**KIRKLEES METROPOLITAN COUNCIL
INVESTMENT & REGENERATION SERVICE**

DELEGATED DECISION TO DETERMINE PLANNING APPLICATIONS

Reference No: 2020/62/90264/E
Site Address: land adj, 20, Quarryside Road, Mirfield, WF14 9QQ
Description: Erection of detached dwelling
Recommending Officer: Rebecca Drake

DECISION – Conditional Full Permission

Block Plan 1: 200

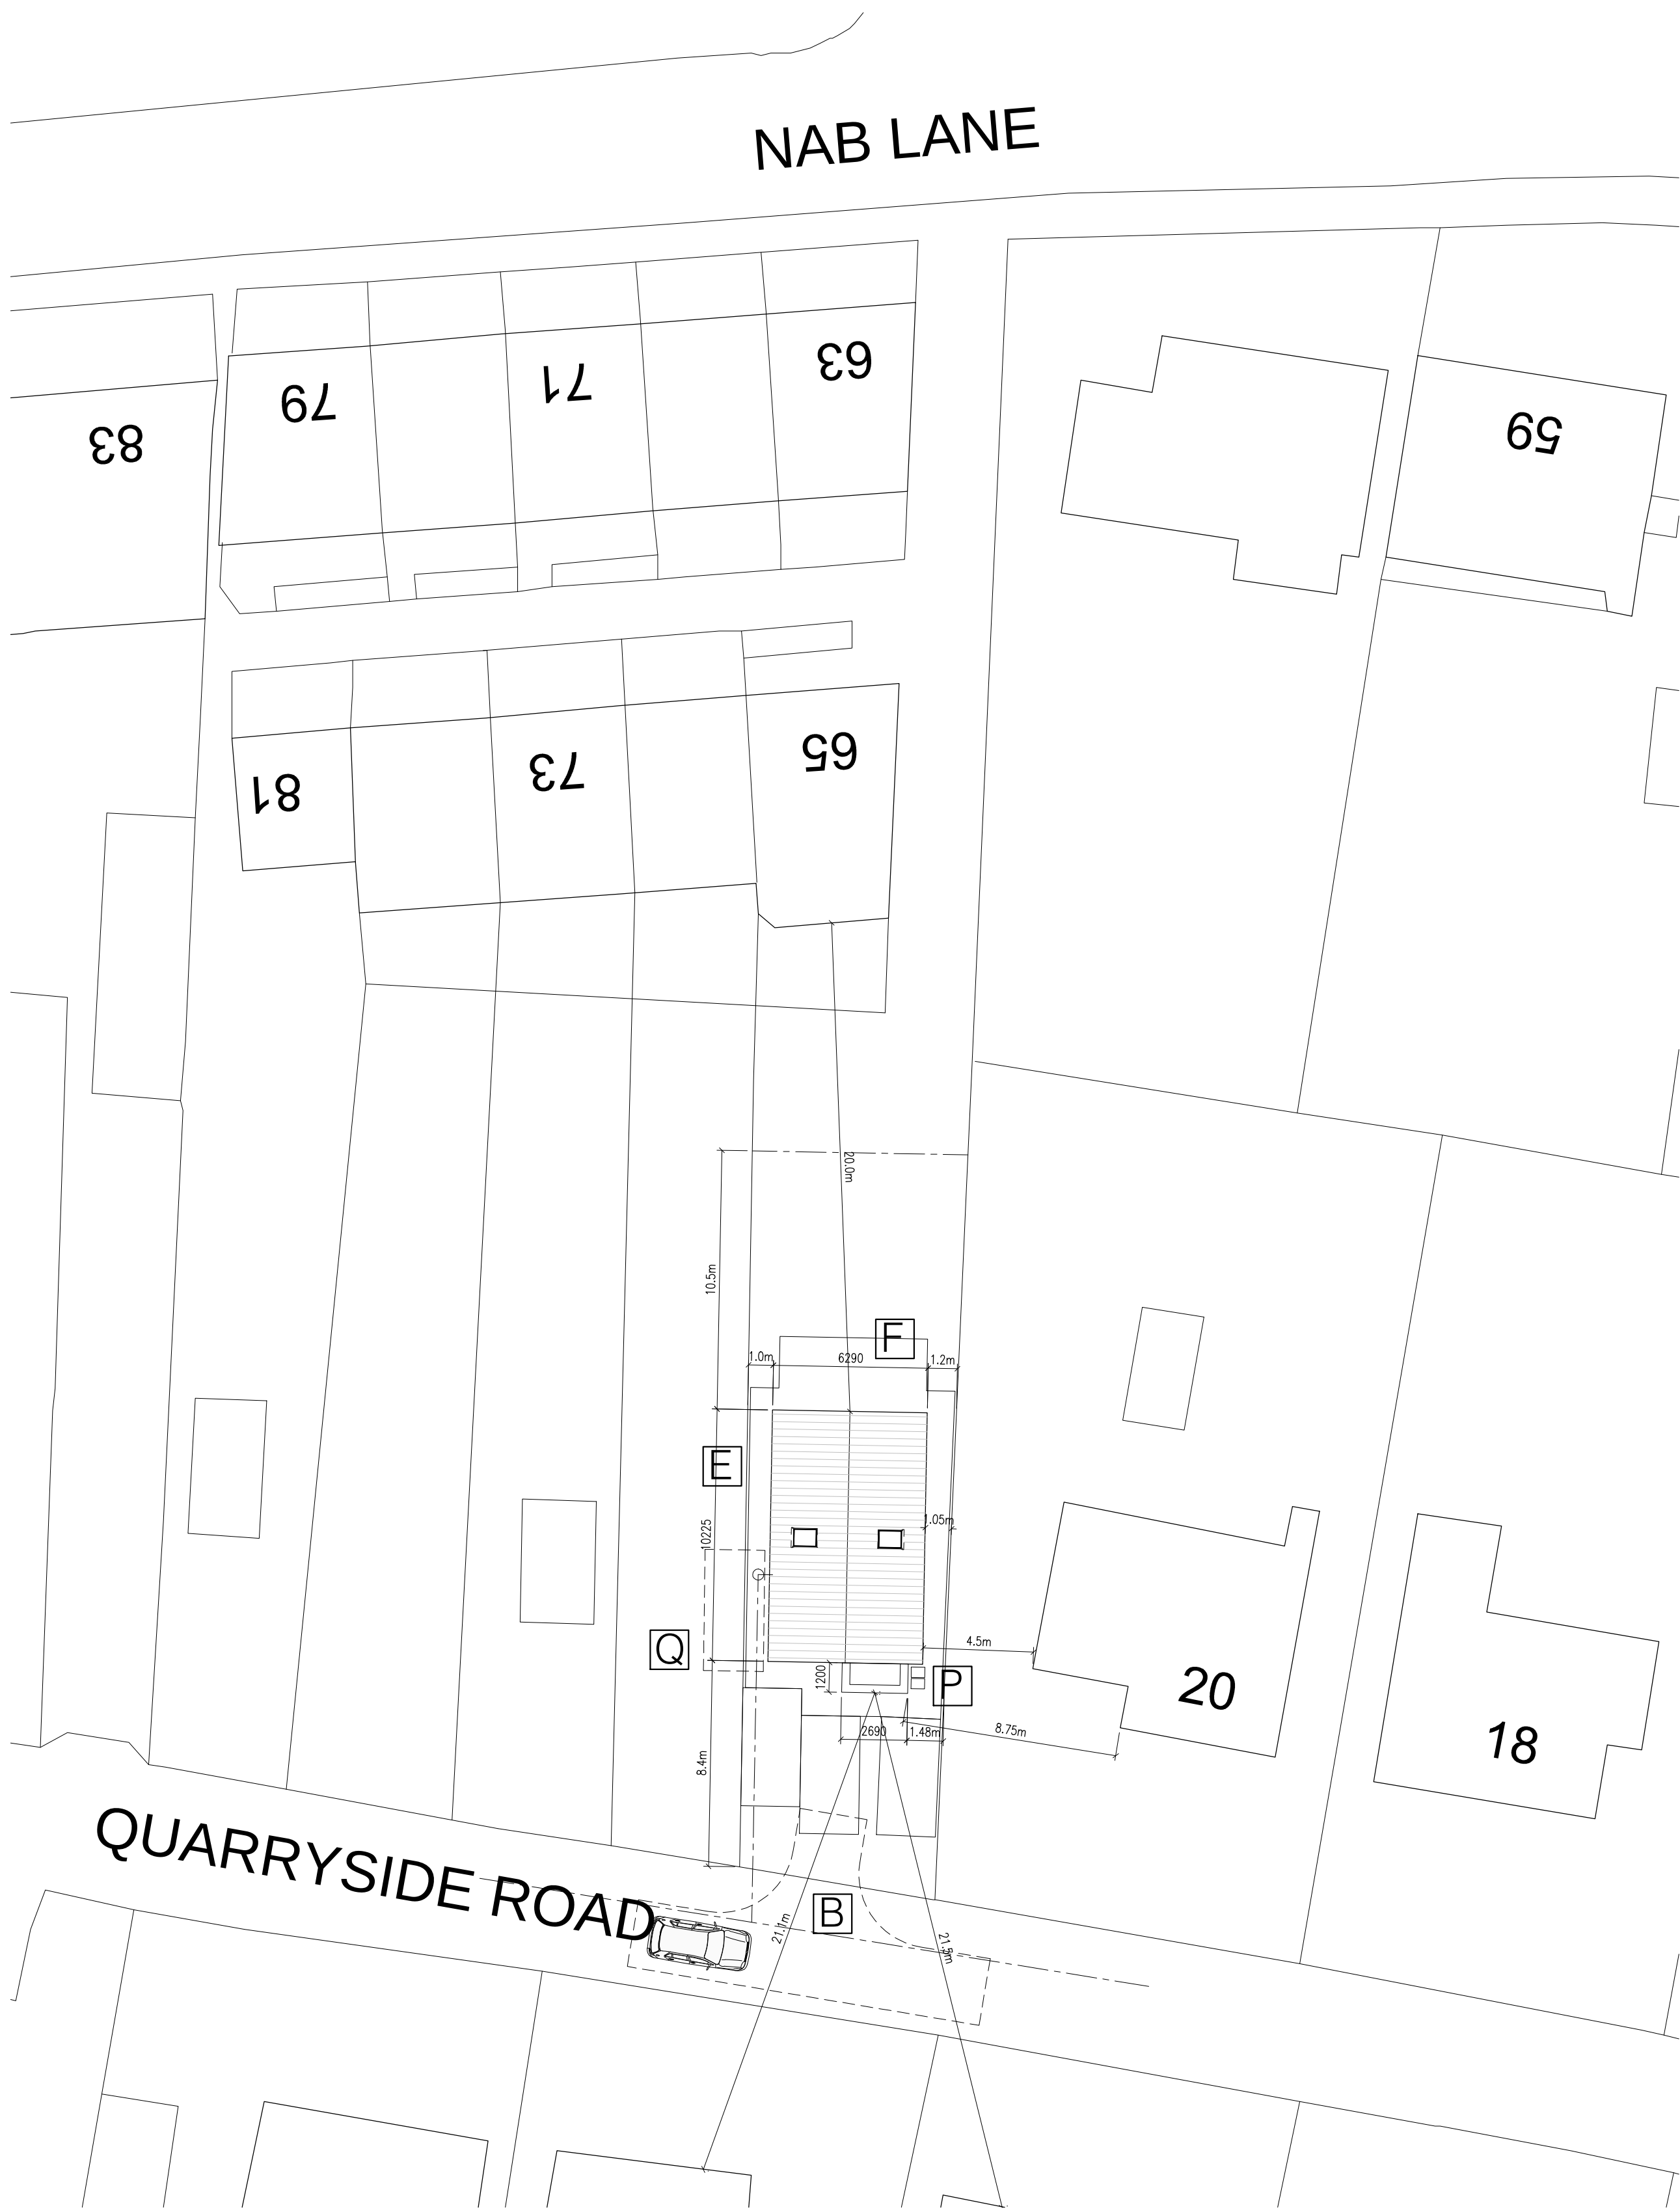
The proposed development has been reviewed by KC Highways DM. They comment that the proposed dwelling would contain four bedrooms and a study with off-street parking for three vehicles as demonstrated on drawing no. (18649)1_Block Plan.

Although this parking arrangement is deemed acceptable for the new dwelling, KC Highways DM were concerned as it appeared to detrimentally impact on the potential parking provision for property nos. 65 and 69, Nab Lane. It was also unclear whether the proposal encroaches on land beyond the red line boundary and onto land belonging to no. 69, Nab Lane. Highways DM also raised concern regarding the intensification of use of Quarryside Road which is too narrow to allow two vehicles to pass for the majority of its length.

- Detail of the number of off-street parking spaces retained by 65 and 69 Nab Lane. The number of bedrooms for each dwelling will also be necessary to ascertain whether there is a shortfall.
- Delineation on a block plan of the boundary between the plot of land owned by 69 Nab Lane and that owned by 65 Nab Lane.

- No. 65, Nab Lane is a 3 bedroom end-terrace and has a detached garage which is accessed from Nab Lane as well as access from Quarryside Road - there is space to turn between the two rows of terraces so a vehicle exits Nab Lane in a forward gear, turns in the

alley and reverses back to the garage. The proposed arrangement will remain the same although the garage is asbestos and proposed for demolition. However, the agent states that the applicant will continue to park in this area or in tandem form down the side of the dwelling.

- No. 69 Nab Lane, is a 3 bedroom mid terrace. It currently has parking off Quarryside Road for three vehicles which comprises a garage and parking apron. There is a raised planting bed which occupies a strip to the boundary which will be removed to retain the provision in the same arrangement.
- In terms of the intensification of Quarryside Road, it is argued that the number of dwellings served by Quarryside Road will remain the same since no. 65, Nab Lane will now be separated from it by the new dwelling. Whilst this will have 3 spaces, the agent contends that the increase in vehicle movements will be minimal

This additional information has been reviewed by KC Highways DM who accept this and considered that, on the basis of the additional information, the proposed development is acceptable in terms of highway safety. They request, should the application be approved, that a condition is imposed requiring that the areas for parking are permeably surfaced.
